Thursday, 16 June 2016

Response to Submissions for SSDA on South East Plot

In response to the Department of Planning & Environment letter on the SSDA submission for the South East Plot of Darling Square, we note the following in respect to the key design matters raised by the Department;

Image 1.19 FJMT-DA-R1002 [07] L00 Podium Ground.pdf

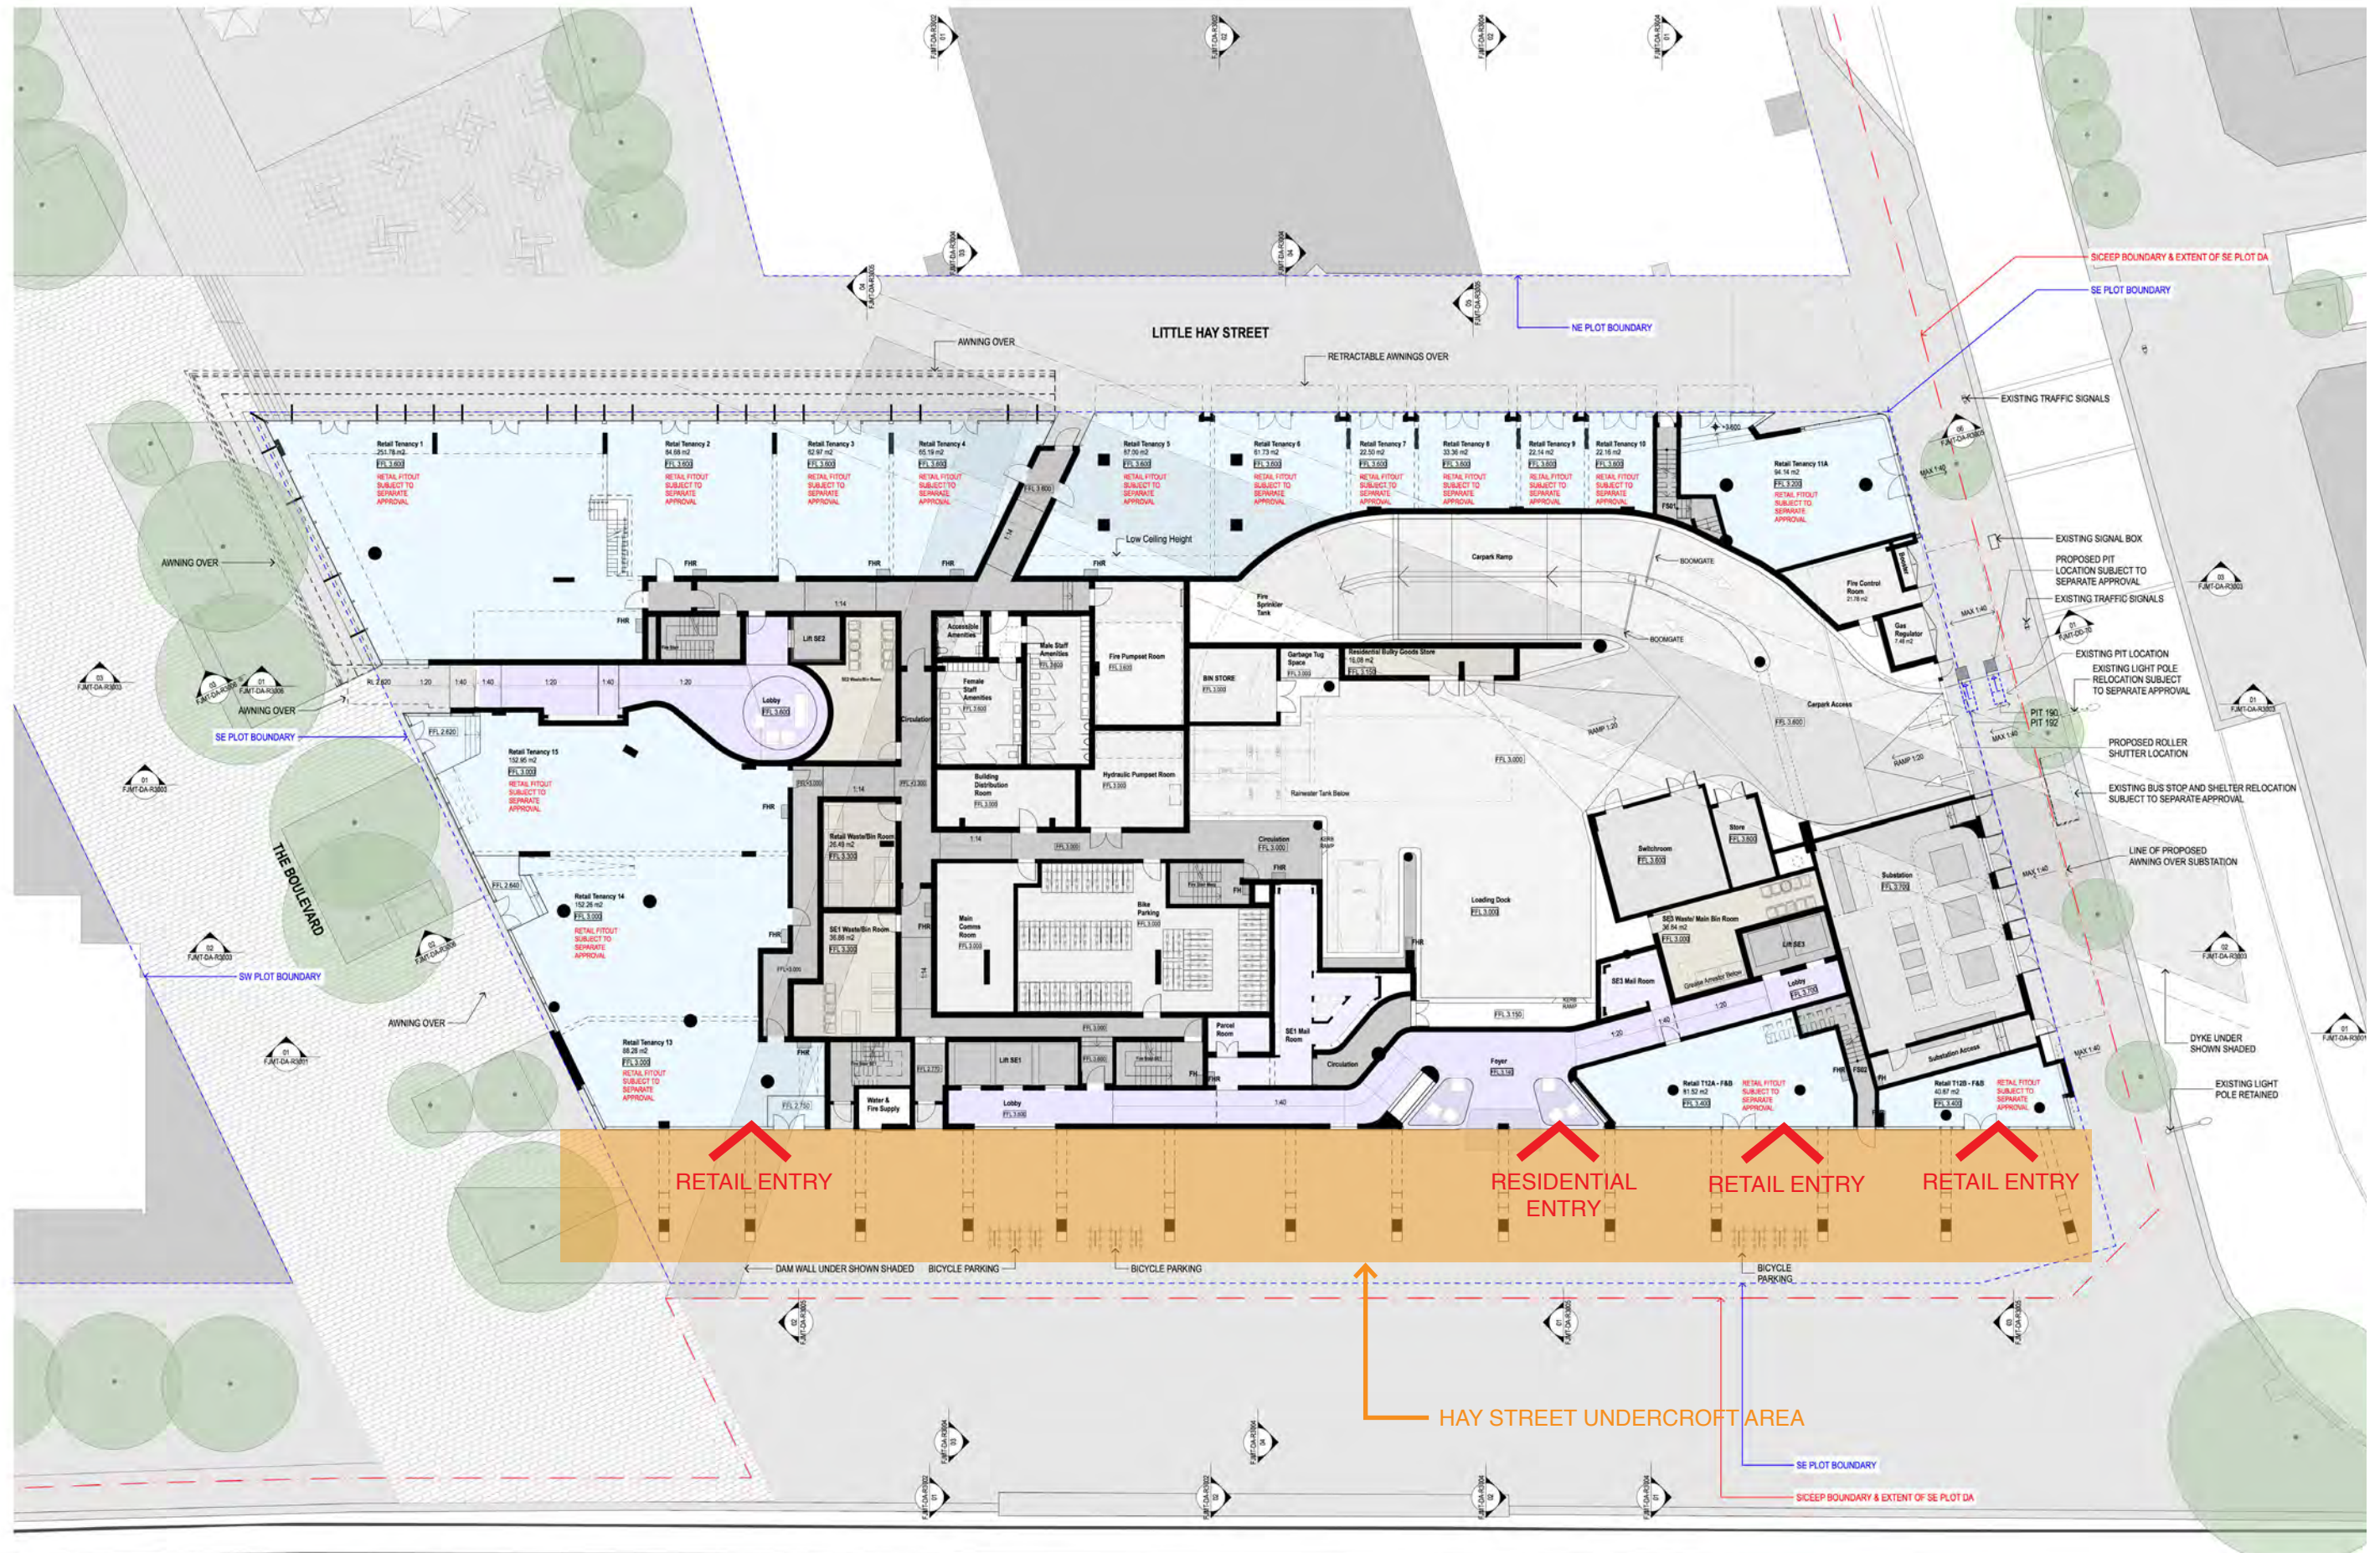
1. *Clarify the proposed use or the undercroft area fronting Hay Street, including what measures will be employed to prevent antisocial behaviour and vagrancy. Consideration should be given to increasing the active uses or other alterations to define this space and give it purpose.*

Please refer to the detailed analysis and commentary on pages 36-41 of FJMT's Architectural Design Report. As noted in the report and repeated again here for clarity.

The Hay Street boundary of the South East Plot is very important to the successful development of an activated and energetic public domain. This edge of the site is characterised by complex relationships to in ground services, subterranean heritage infrastructure, overland flow path requirements, underground stormwater, Light Rail infrastructure and the adjacent Paddy's Markets.

In particular, the design responds to the overland flow requirements, as well as the provision of stormwater infrastructure along the southern boundary. The colonnade design response must honour very strict alignment and height constraints, as illustrated in Diagram 01.

A. The overland flow path requires a volume along the southern boundary 9m wide and 6m high (see diagram 2)

- B. No built works can protrude within a 5.5m wide space between the supporting structure and the 9m setback façade line, including fixed street furniture or bicycle hoops. (see diagram 3)

- C. All construction must be arranged so as to facilitate a minimum 6m diagonal clear space refer diagram 04.
